**From:** Timothy Ingraham <tim.ingraham@gmail.com>  
**To:** Jeanie Bourke <JMB@portlandmaine.gov>  
**Date:** 1/12/2016 11:48 AM  
**Subject:** Re: 314 Stevens Avenue - Admin Author #2015-183  
**Attachments:** Floor Plan.pdf

314 Stevens Ave, Portland, ME 04103 - Basement Plan

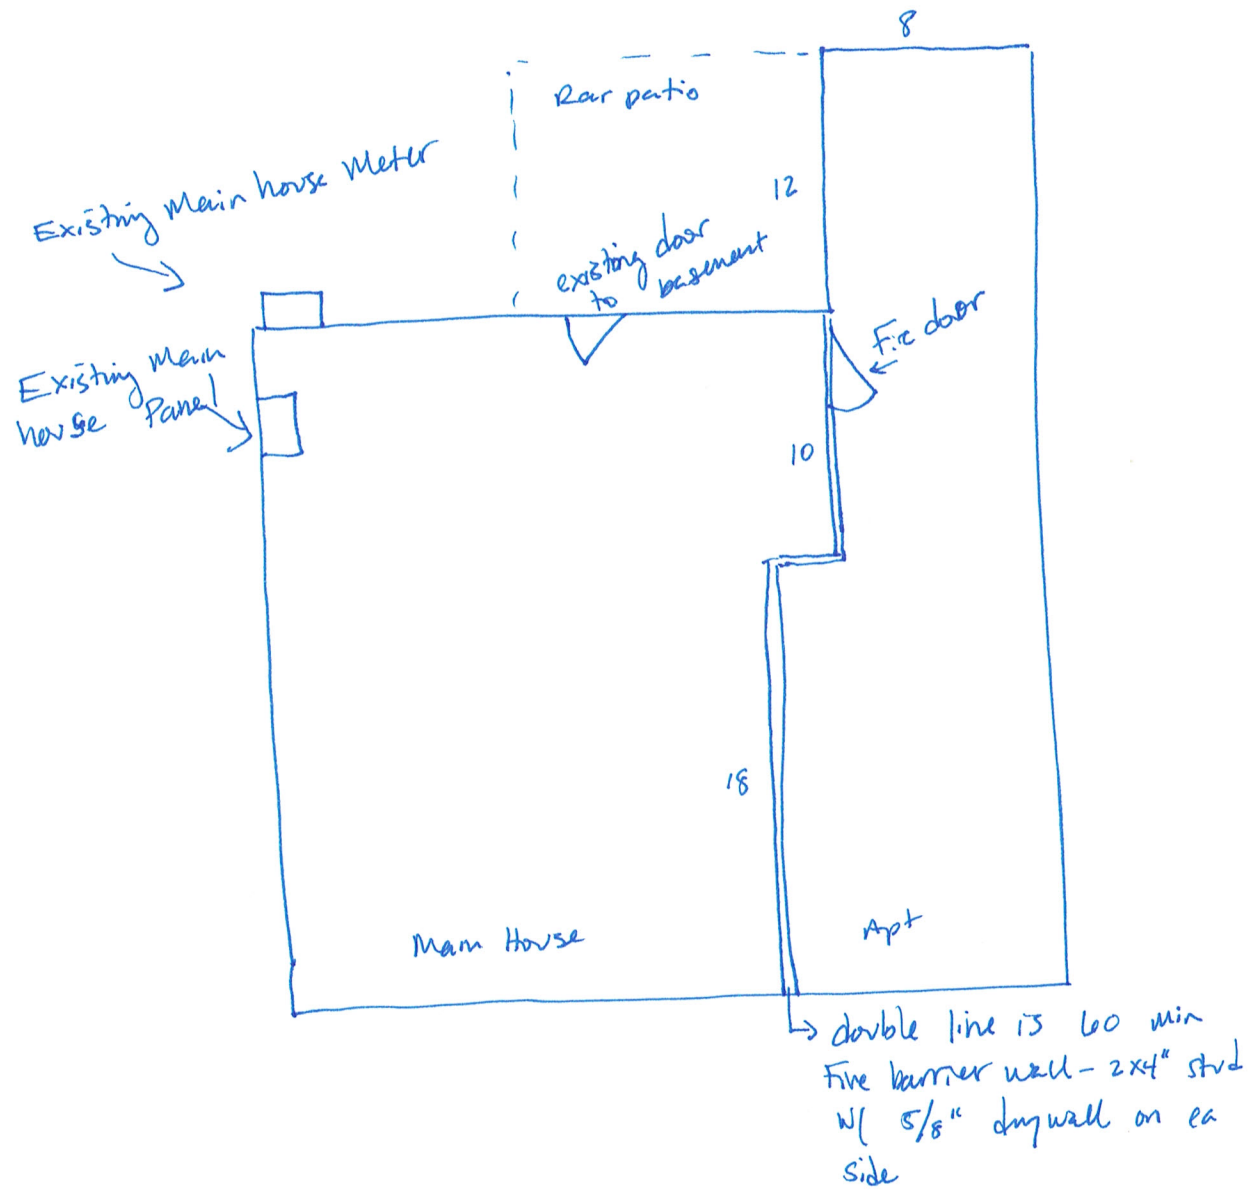
> In order for me to approve the permit, I will need details on how the fire  
> separation between the units will be continued in the basement. As we  
> discussed earlier today, please provide a basement plan with your  
> construction details on how to achieve this. You can add a 1 hour fire door  
> if you want to maintain access to both sides of the basement. In addition,  
> as mentioned, a separate electrical meter will be required for the new  
> dwelling.

Floor Plan

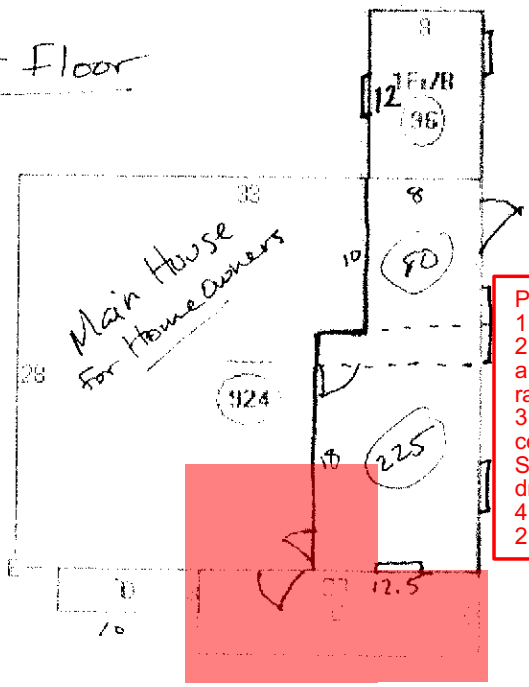
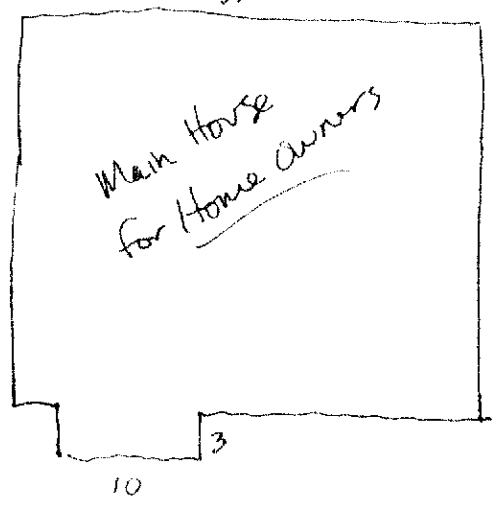
> As I agreed, I have added some notes on the plans and application for the  
> other items, ie. to remove the new entry deck and steps from the scope and  
> that the door infill will now have 5/8" firecode drywall to separate the  
> units.
